Phone: 01772 533235
Email: Kathryn.Walsh@lancashire.gov.uk
Your ref: CEA/2022/0488
Our ref: CEA/2022/0488/HDC/KW
Date: 30 August 2022

Location: 62 Cumbrian Way, Burnley, Ightenhill
Proposal: Replace garage doors/brick-up & external works to garage walls
Grid Ref: 381992, 433815

Proposed Floor Plan

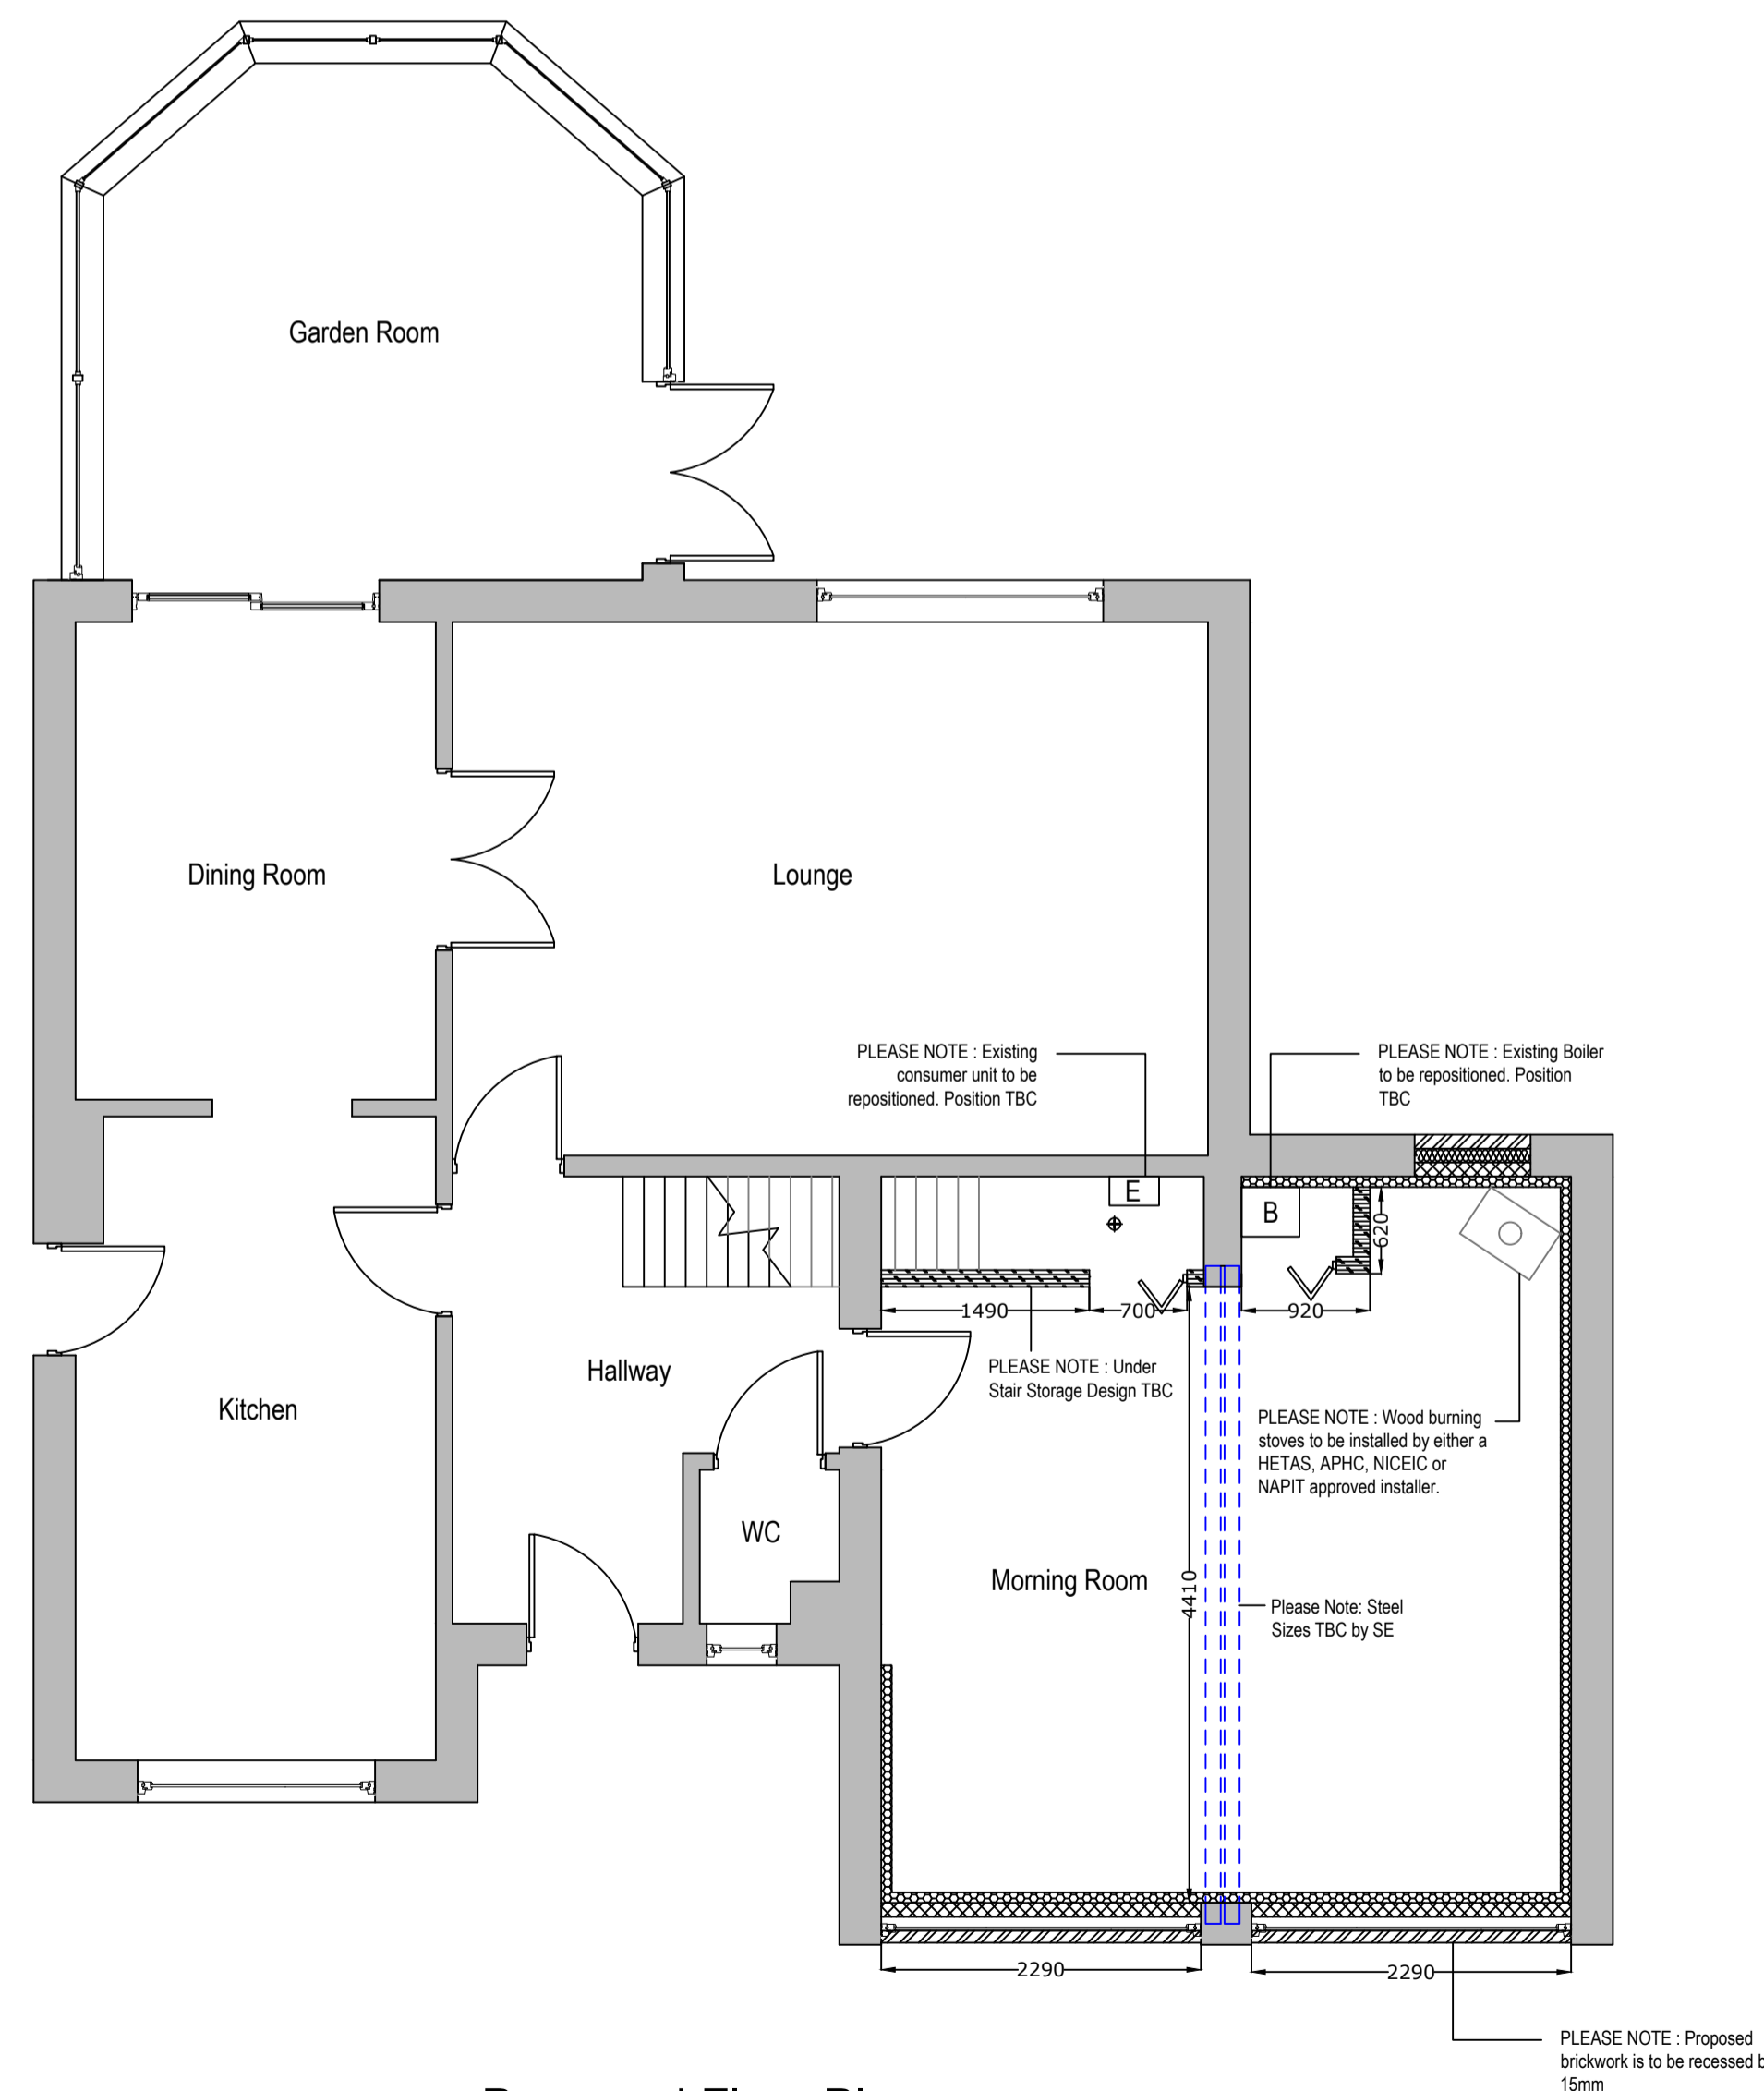
Whilst in principle Lancashire County Council have no objections to the proposed application, the development will result in the removal of a double garage which reduces the available off-street parking provisions.

A 4-bedroom dwelling should provide at least 3 off street parking spaces to ensure a negligible impact on highway safety and highway capacity within the immediate vicinity of the site. These spaces should measure 5m in length and 2.4m wide, where they are adjacent to a fence or similar obstruction an additional width of 0.6m should be provided. Where the driveway has shared pedestrian access an additional 0.8m should be provided. If 3 vehicles are parked within a driveway, it is expected that at least 2 vehicles can enter and exit the area independently.

Whilst the retention of the driveway will support the parking of 2 vehicles, 1 additional space should be provided elsewhere within the boundary of the site. In order to progress the application, we would look for a plan showing at least 3 off-street parking spaces meeting the parking criteria mentioned above.
